2 October 2020

SF2019/159515; WST19/00193/03

SSI9371; North Star to Queensland Border (NS2B) Inland Rail Project; Review of EIS

FIGURE 6.4 INDICATIVE DESIGN FOR THE CROSSING LOOP AND MAINTENANCE SIDING

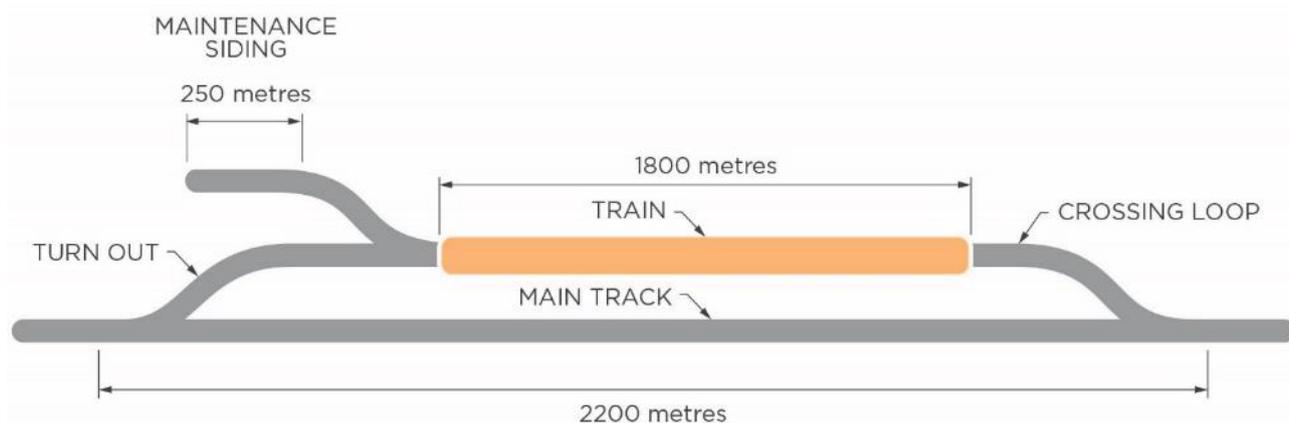
- In Chapter 20 Section 4.5, TfNSW is not listed as a stakeholder. TfNSW needs to be added as a stakeholder.
- Appendix M states a crossing loop is included in the project, however, the location of loop is not yet confirmed. It is requested that the proponent please advise the location of the crossing loop. Crossing loops are to be clear of road and rail interfaces.

FIGURE 6.9 AERIAL VIEW OF THE PROPOSED BRUXNER WAY REALIGNMENT

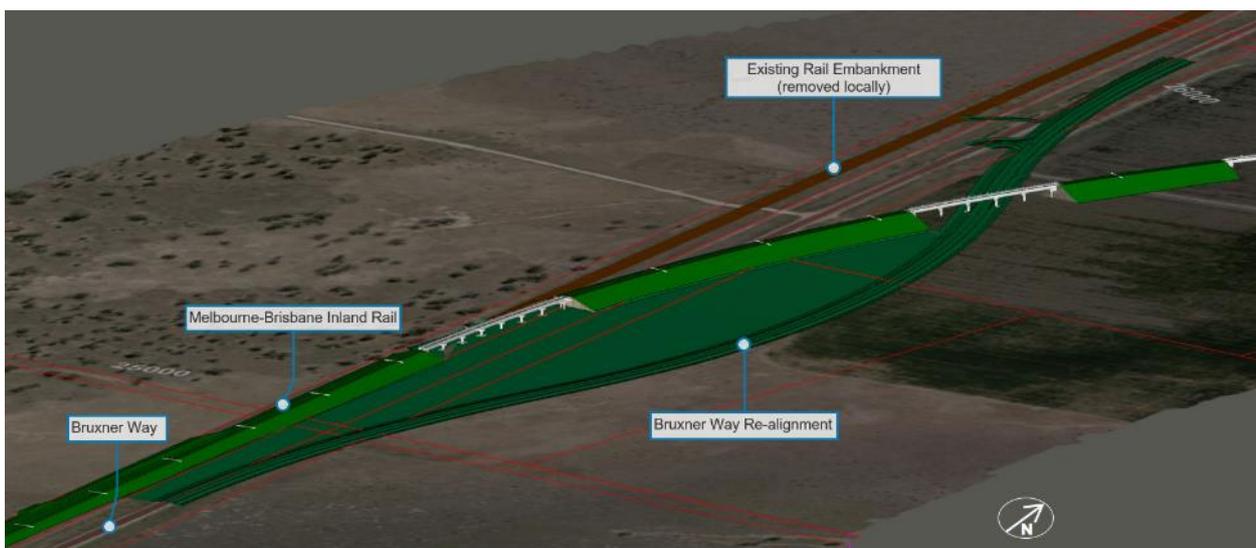
- TfNSW has concerns and does not support the current design of the proposed Bruxner Way (MR462) Rail Overpass. Specifically:
 - It is proposed that the bridge will have a clearance of 5.4 metres over Bruxner Way. 5.4 metre clearance is insufficient to allow over-size/over-mass loads that use this road including agricultural machinery/implements. In addition, a 5.4 metre clearance places restrictions on the road authority to raise the road to improve road flood immunity or basic re-sheeting projects. Commiserate with other new road and rail bridges over classified roads in the region, TfNSW requires the rail over pass to achieve 6.5m clearance over Bruxner Way.

- The road/rail interface at this location appears to have been designed in the best interests of the rail alignment with little consideration of the road impacts. Specifically, the current road alignment is straight without any hazards in the clear zone, however the proposal is for road alignment to be moved and introduce three curves in a 100km/h speed environment. TfNSW requests that the rail alignment be adjusted to reduce the impact on the current Bruxner Way alignment.
